Date: 26th November 2011
To: Planning
Cc: -
From: Miriam Hill
Subject: S6/2011/2227/MA – Wildewood, Kentish Lane, Brookmans Park
Erection of linked swimming pool and gym and erection of terrace with retaining walls

I have reviewed the proposal for the above site and refer to drawing number 10424-S004-B and 10424-A1-PL01-A.

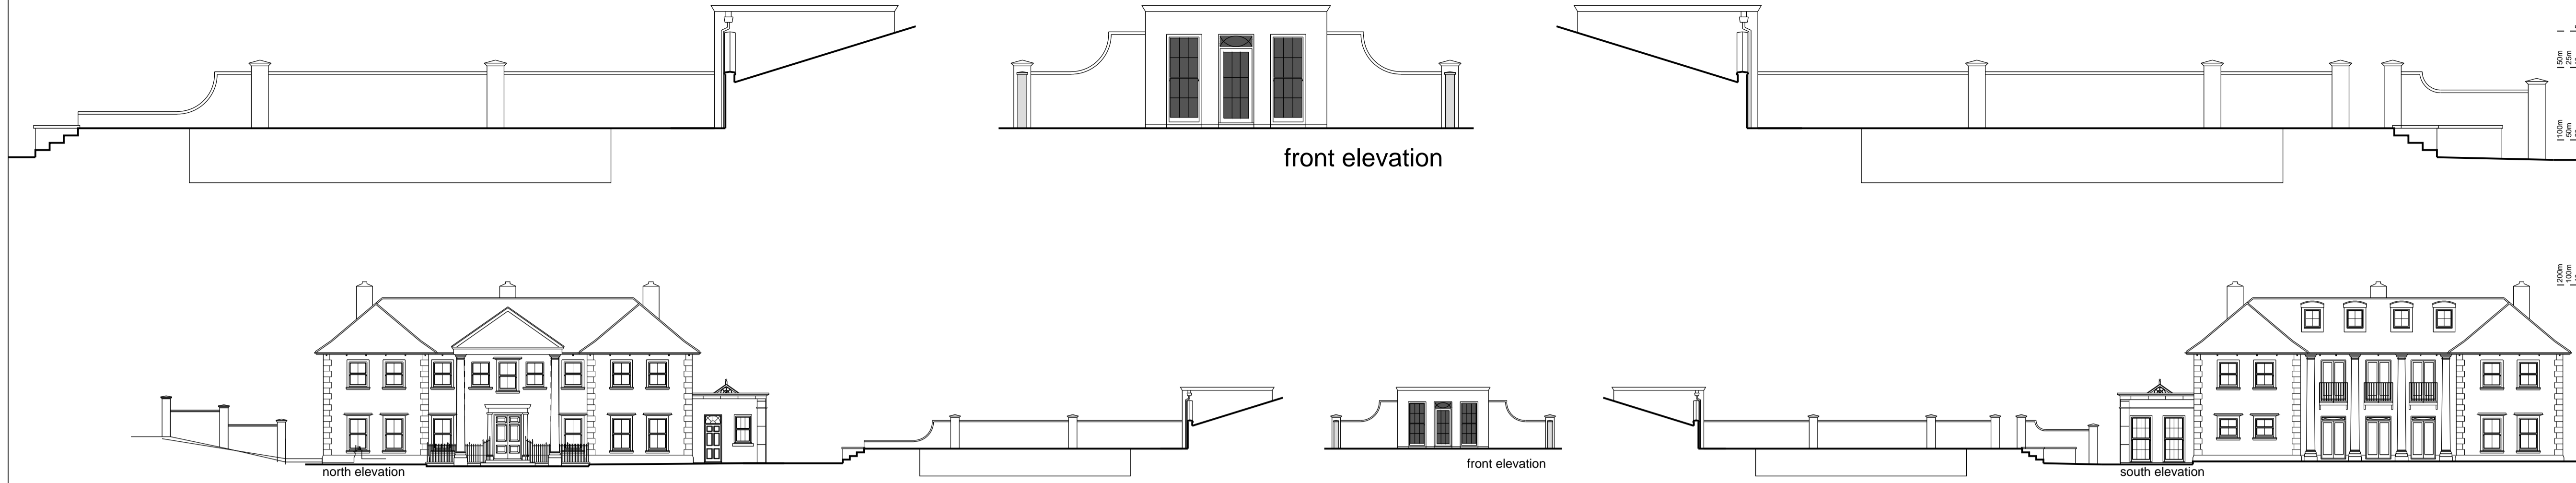
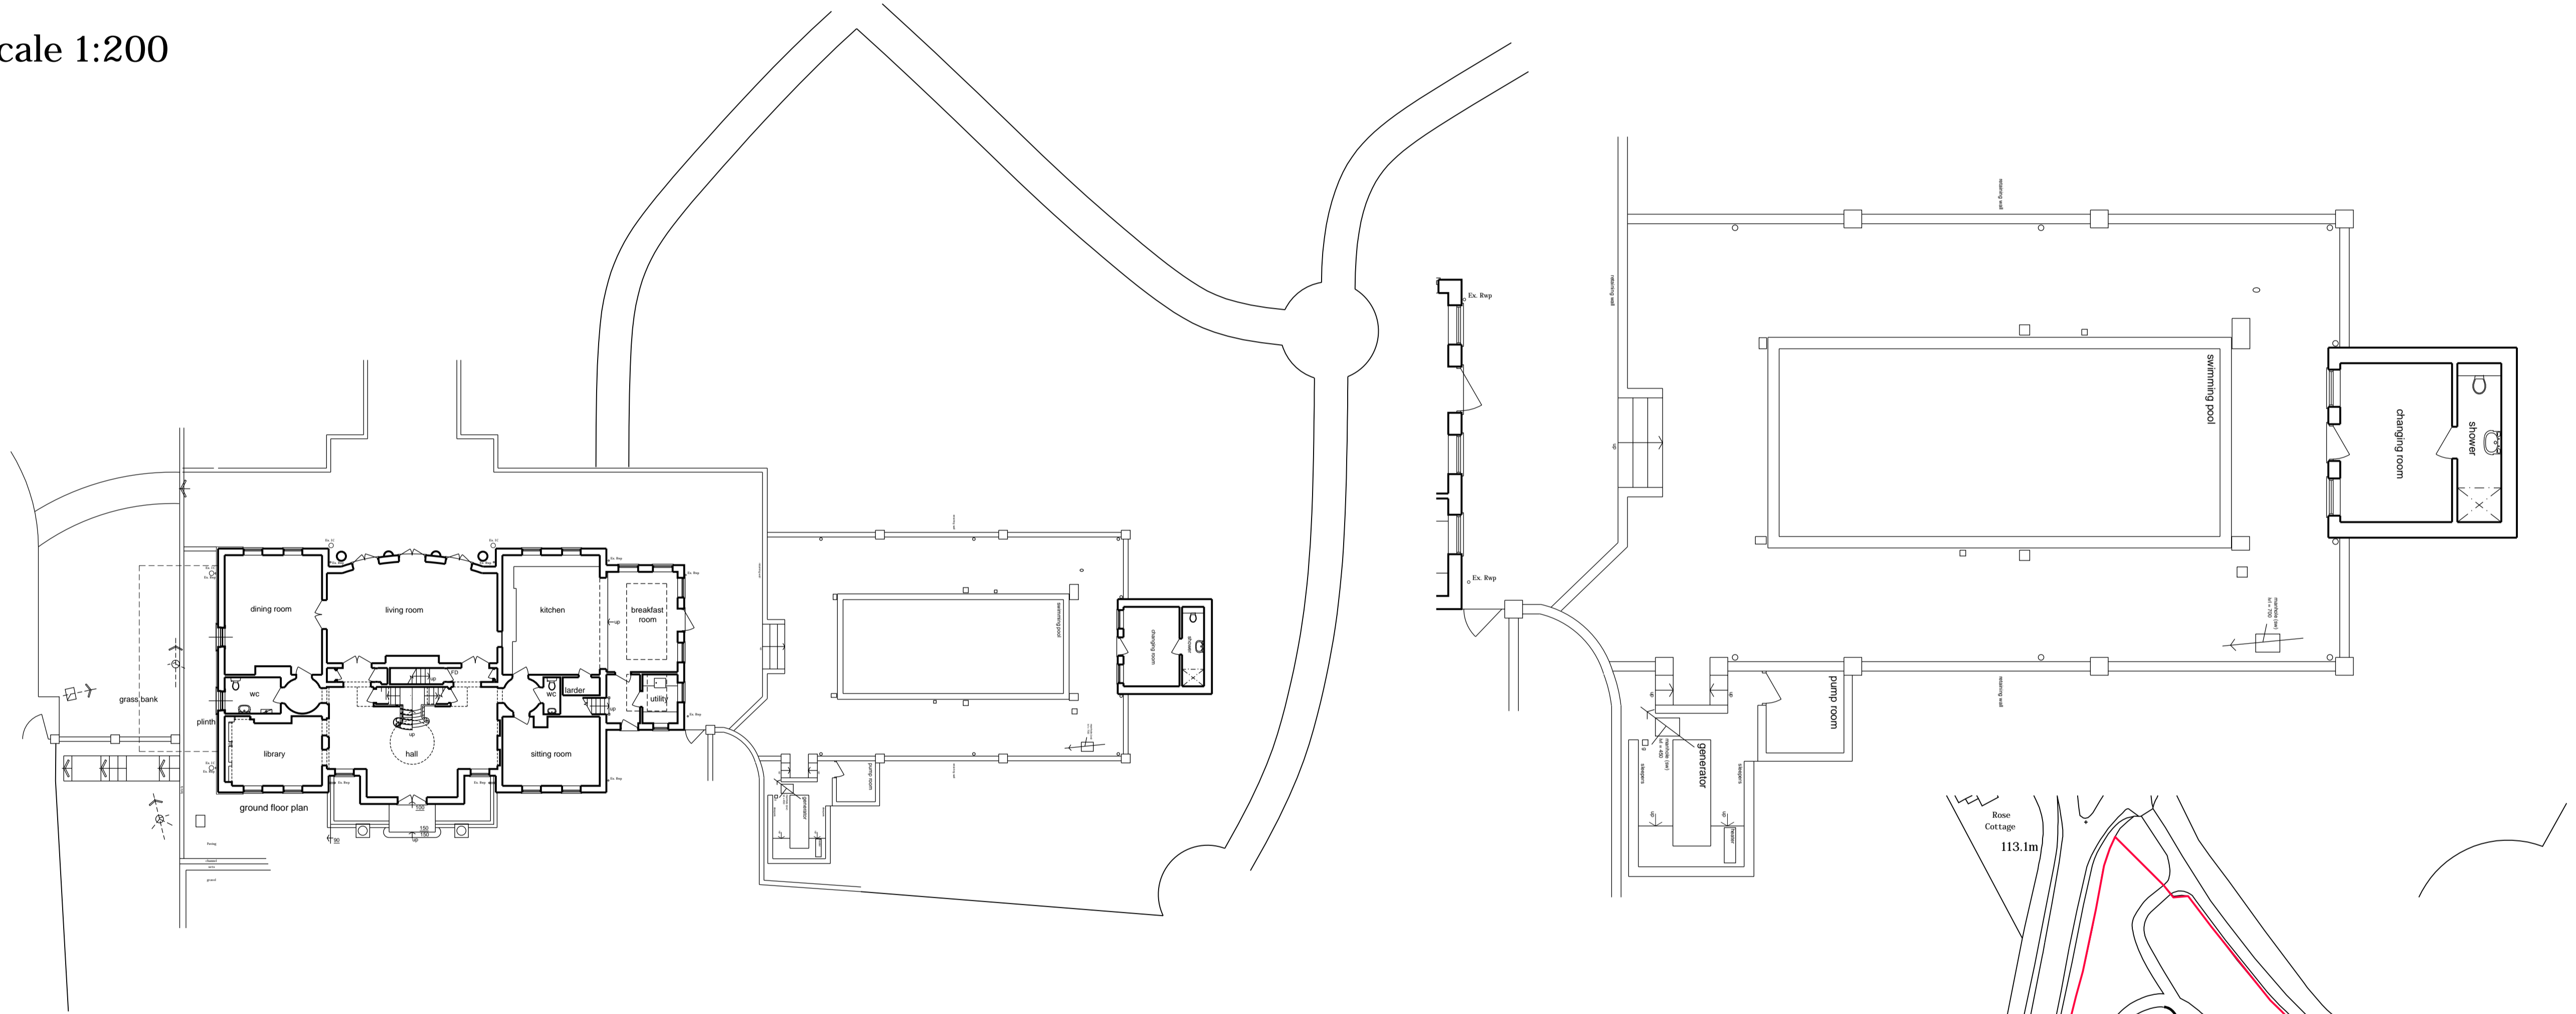
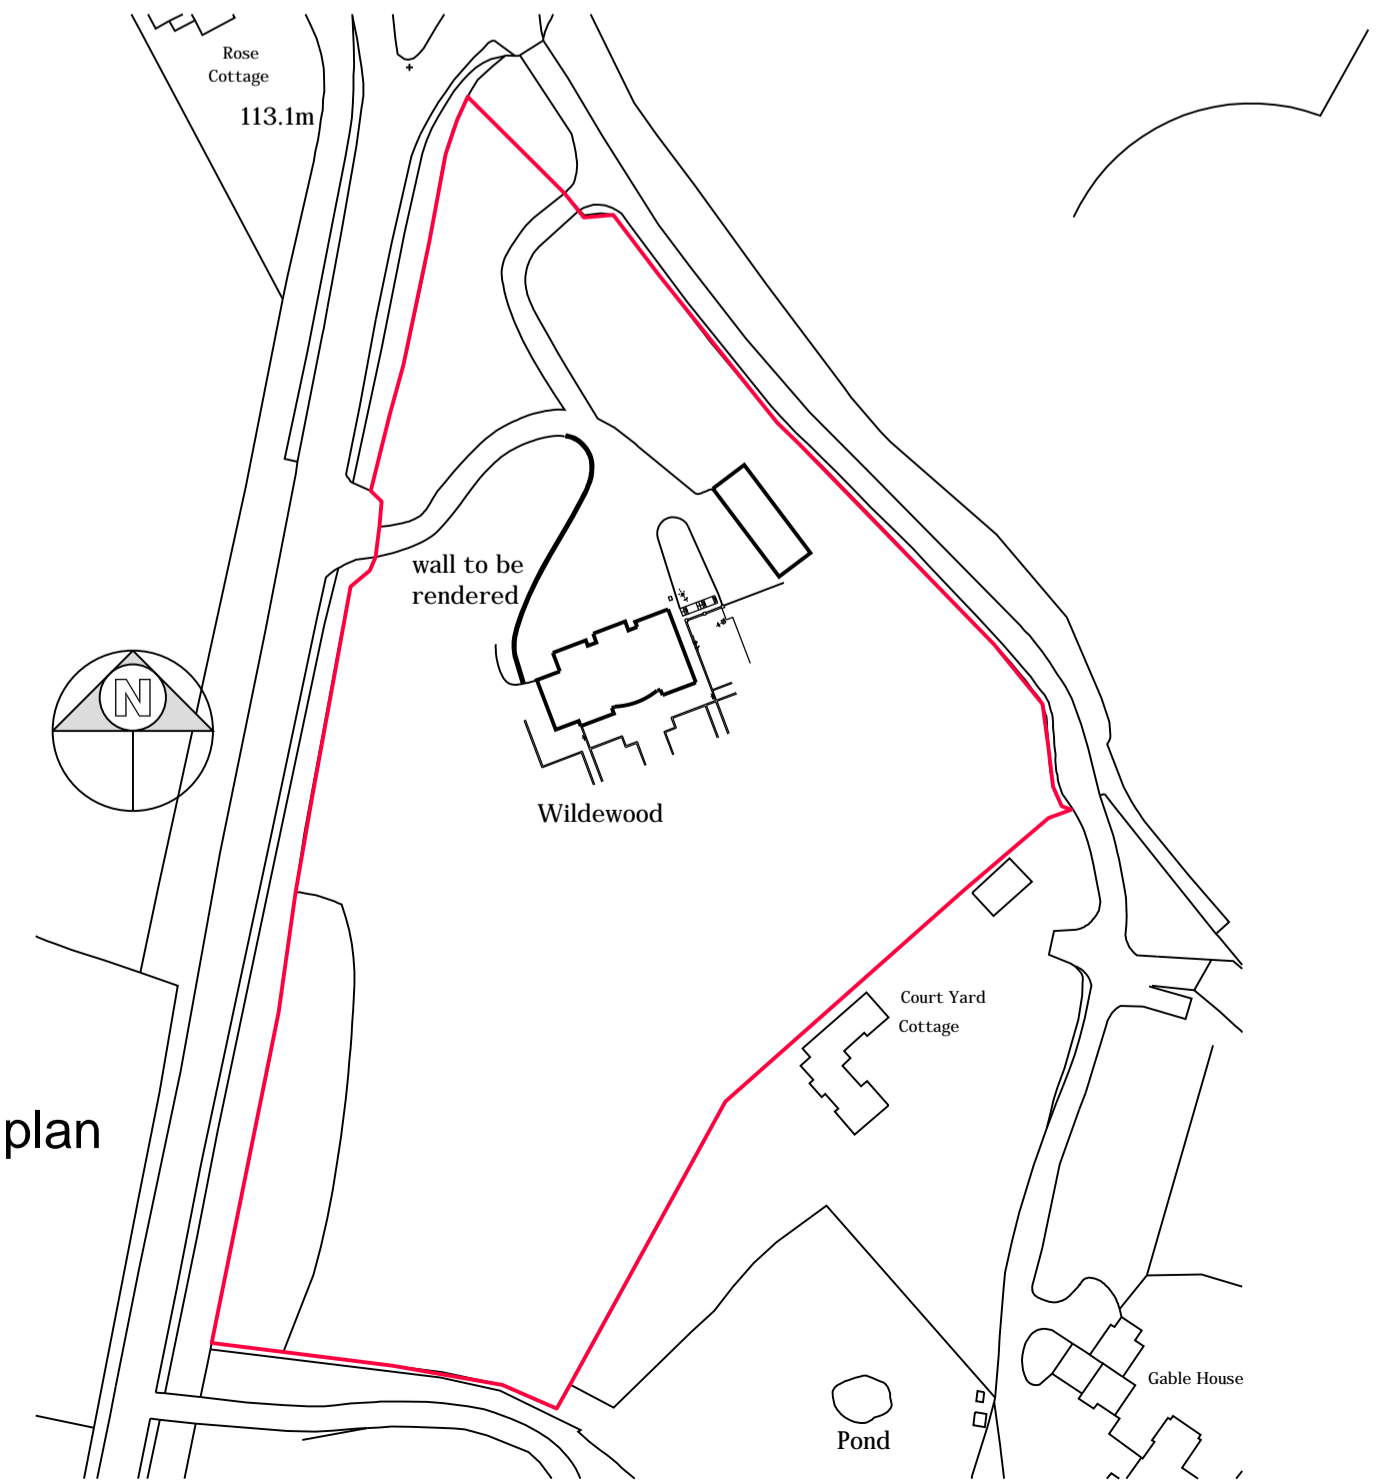
Will any works, regarding of the land, storage of materials or parking occur within the root protection area of the trees? If the answer is yes to any of these points a tree protection statement will be required. The trees which boundary Kentish Lane and the property, are a useful screen and they may be damaged if the soil is compacted, excavated or reprofiled. The method statement which complies with BS5837:2005 Trees in Relation to Construction.

10424-A1-PL01-A

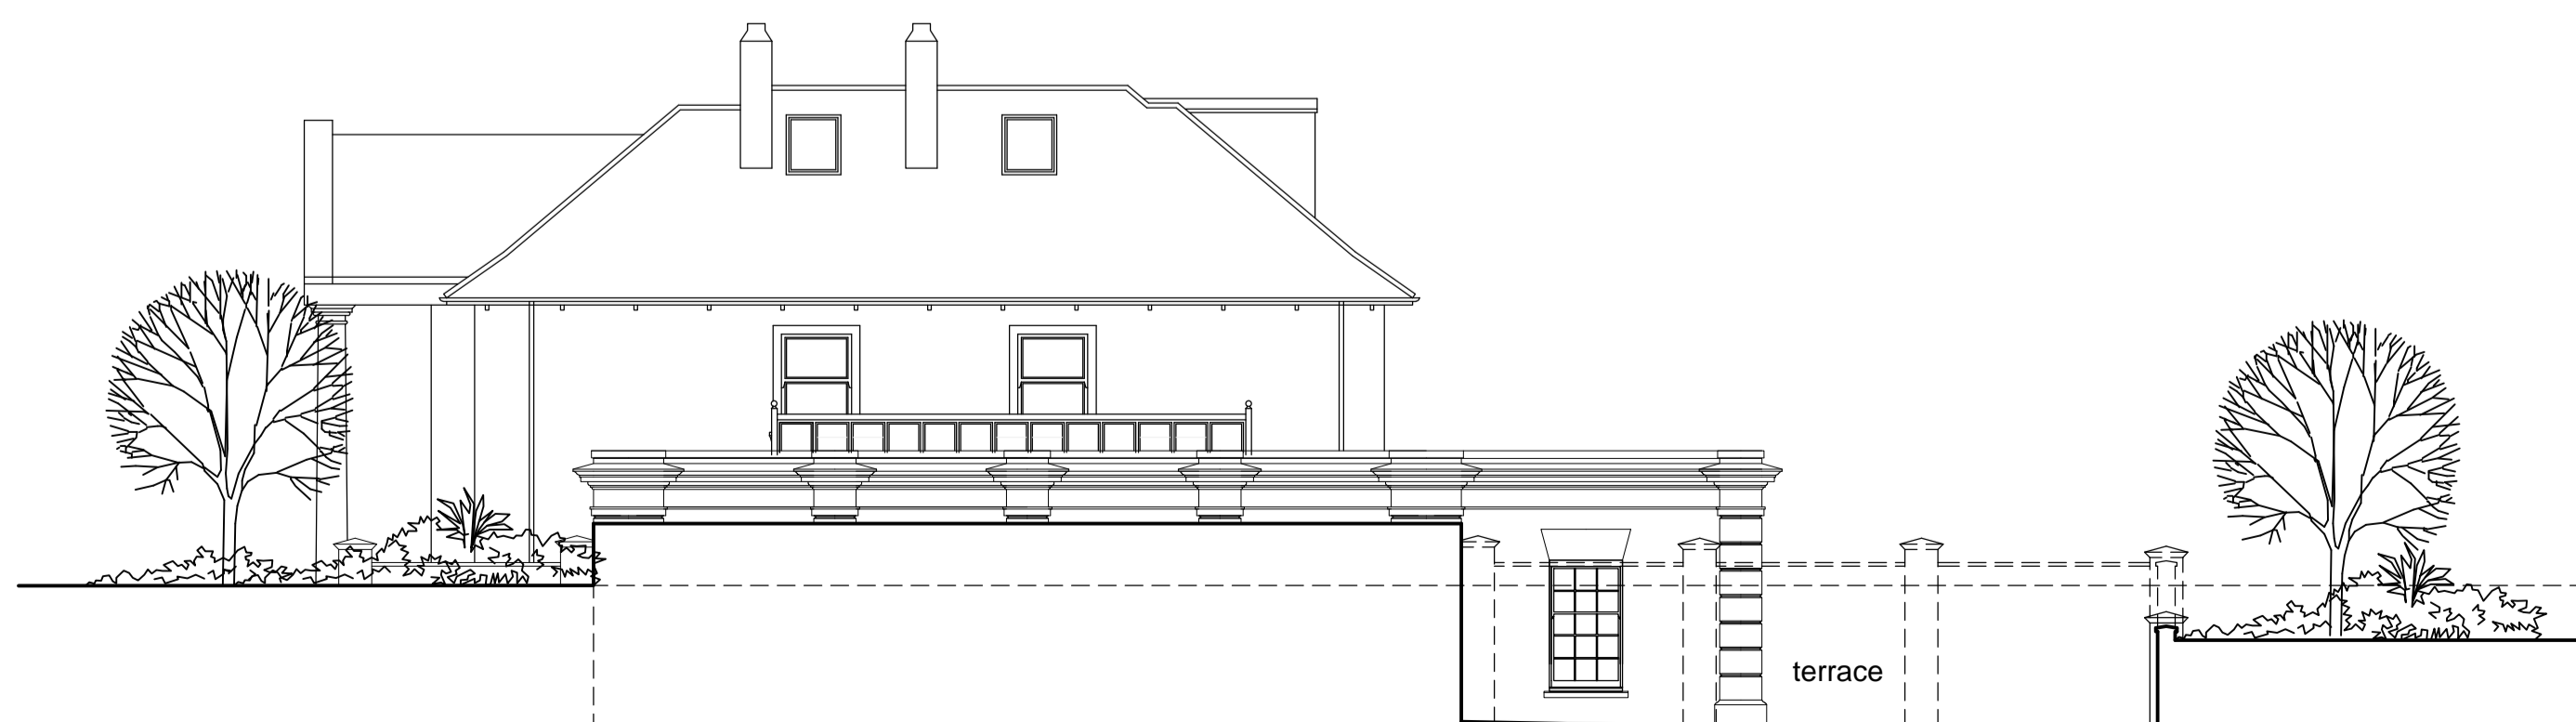
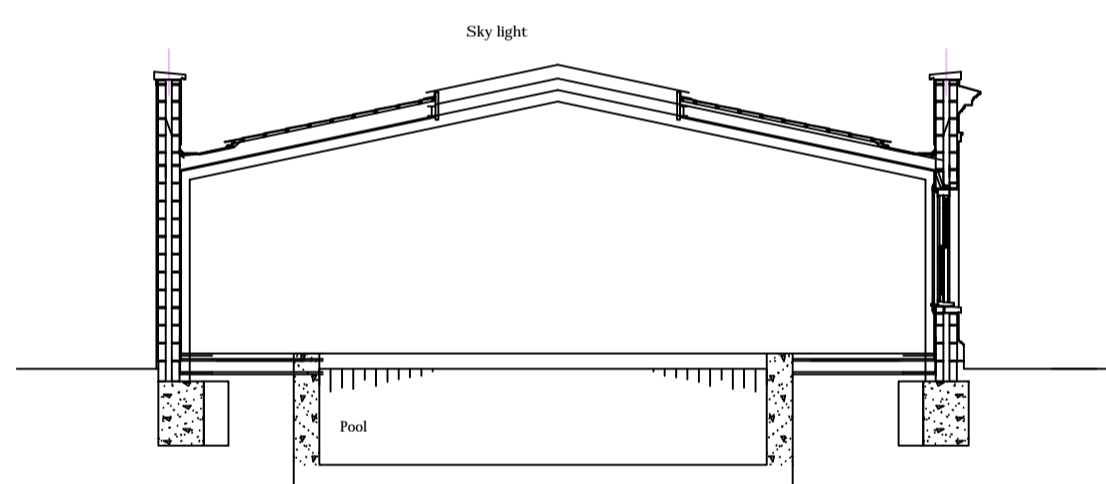
We would need more information about the banking indicated to the west of the proposed building.
